**Road Infrastructure Design Report**  
**Strategic Housing Development**  
**Baldoyle-Stapolin Growth Area 3,**  
**Baldoyle, Dublin 13**

**ROAD INFRASTRUCTURE DESIGN REPORT**

**STRATEGIC HOUSING DEVELOPMENT, BALDOYLE-STAPOLIN GROWTH AREA 3,  
BALDOYLE, DUBLIN 13**

Drawing file: Engineering / BD-CSC-ZZ-G3-DR-C-0123_Proposed Road Cross Sections-A1 Colour.pdf

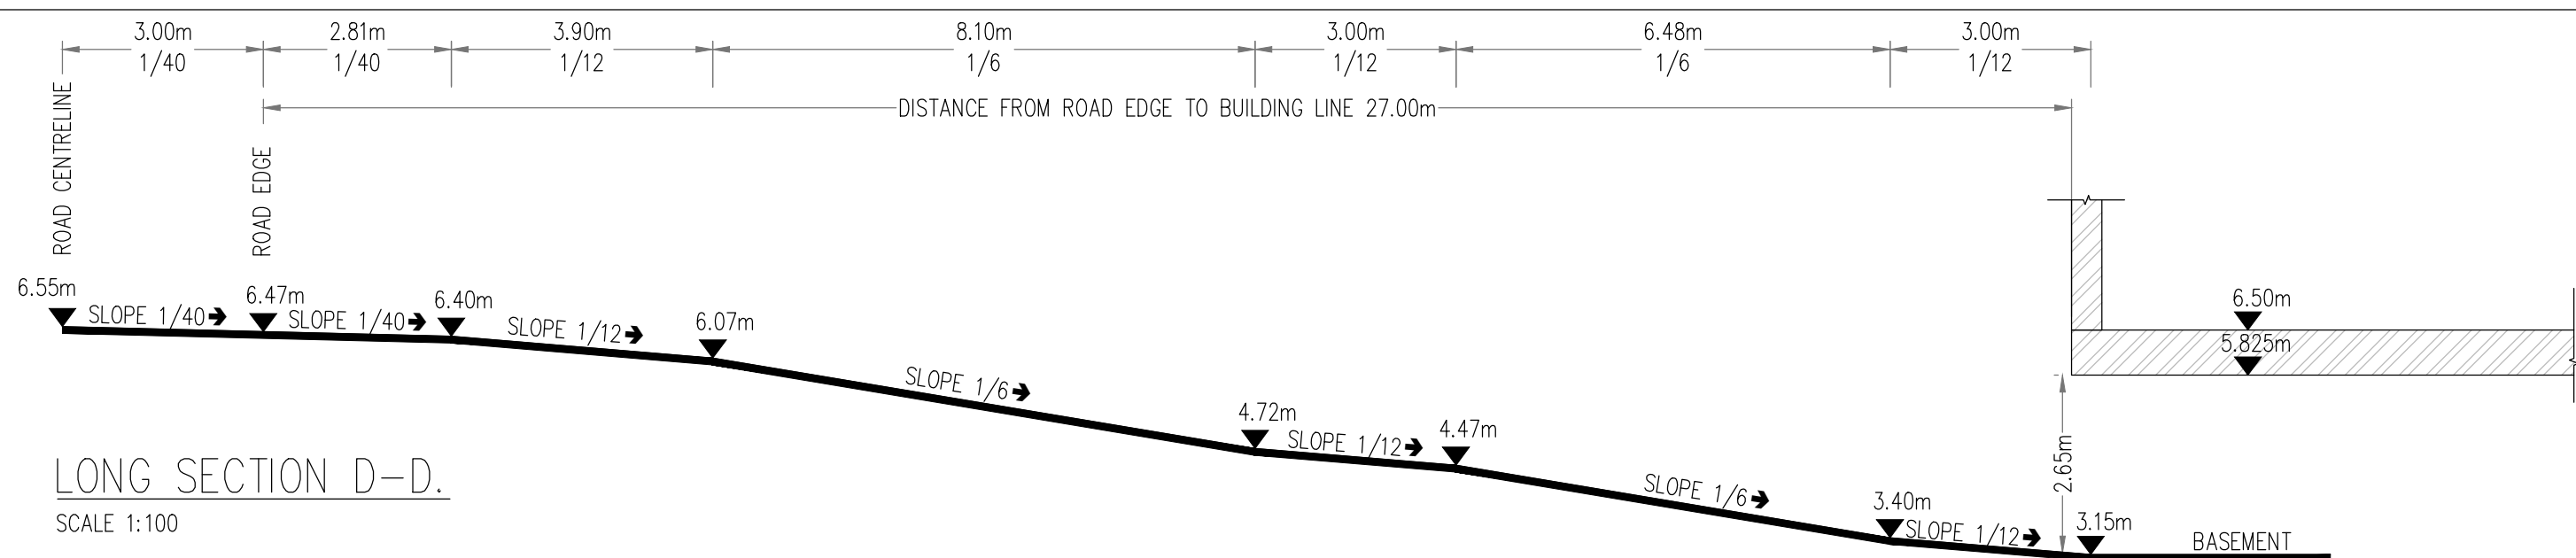
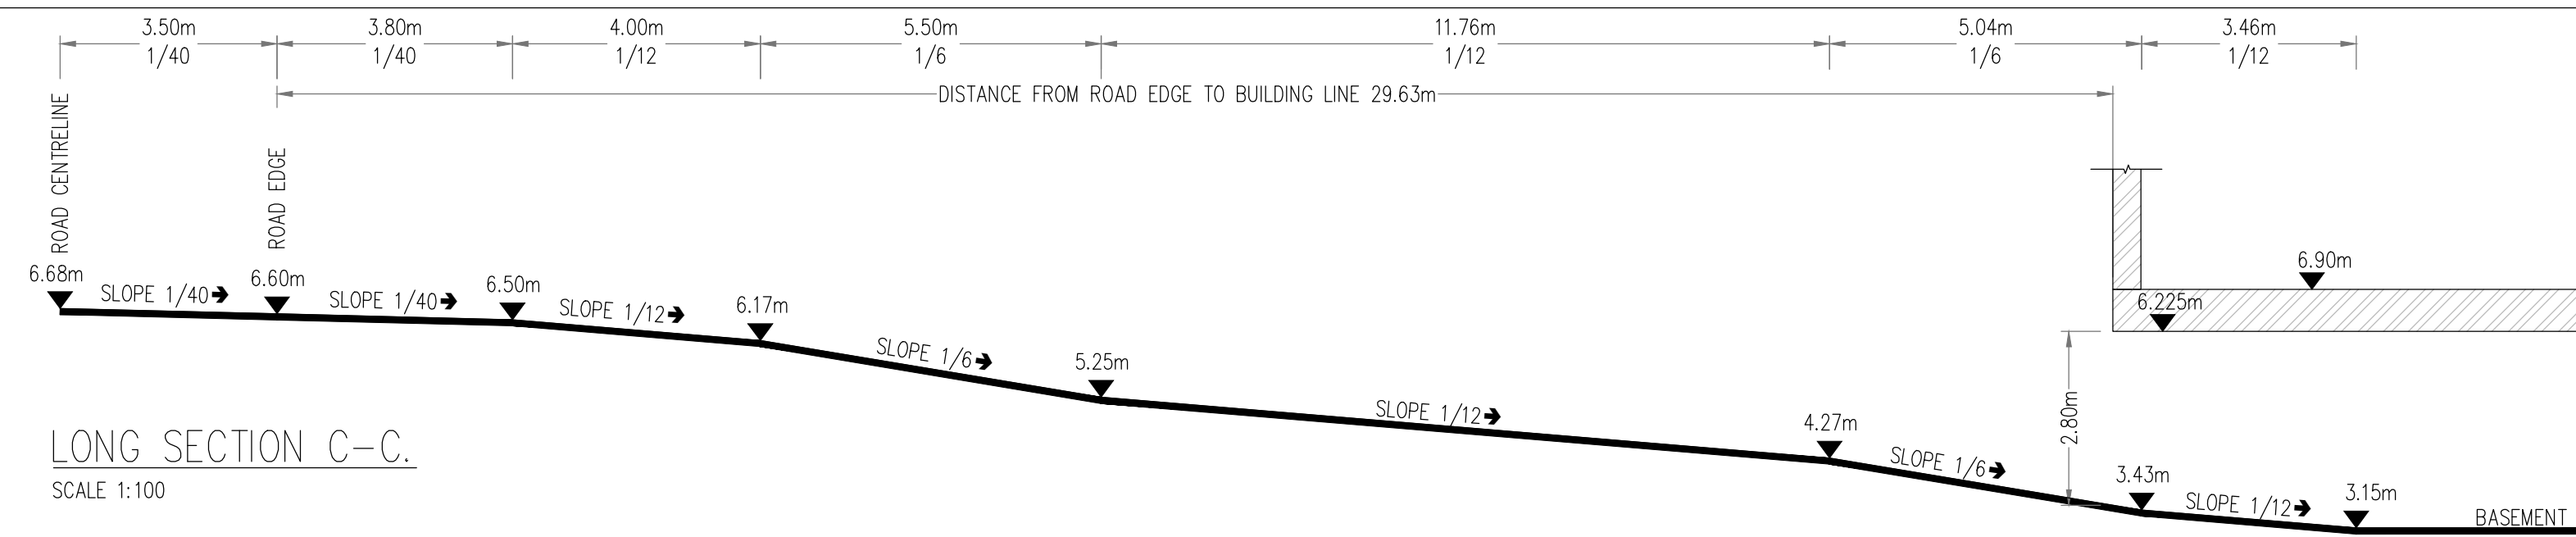
*“Basement car park should be designed in accordance with the requirements of the latest edition of the Design recommendations for multi-storey and underground car parks published by the IStructE. It is noted that the Transportation Planning Section have highlighted a number of concerns over the layout and design of all the basement and podium levels. This needs further consideration.”*

- (a) Parking spaces 4.8m long by 2.4m wide are not considered sufficient to accommodate larger cars; spaces 5.0m long by 2.5m wide should instead be provided.
- (b) Details should be provided in respect of the access ramps to basement car parks, in particular clearance heights and gradients (including transitions); sectional views of these ramps should be provided.

(b) Longitudinal sections of the 2no. access ramps to the Block G basement car parks are shown on CS Consulting drawing BD-CSC-ZZ-G3-DR-C-0123. These provide details of ramp gradients and perpendicular clearances.
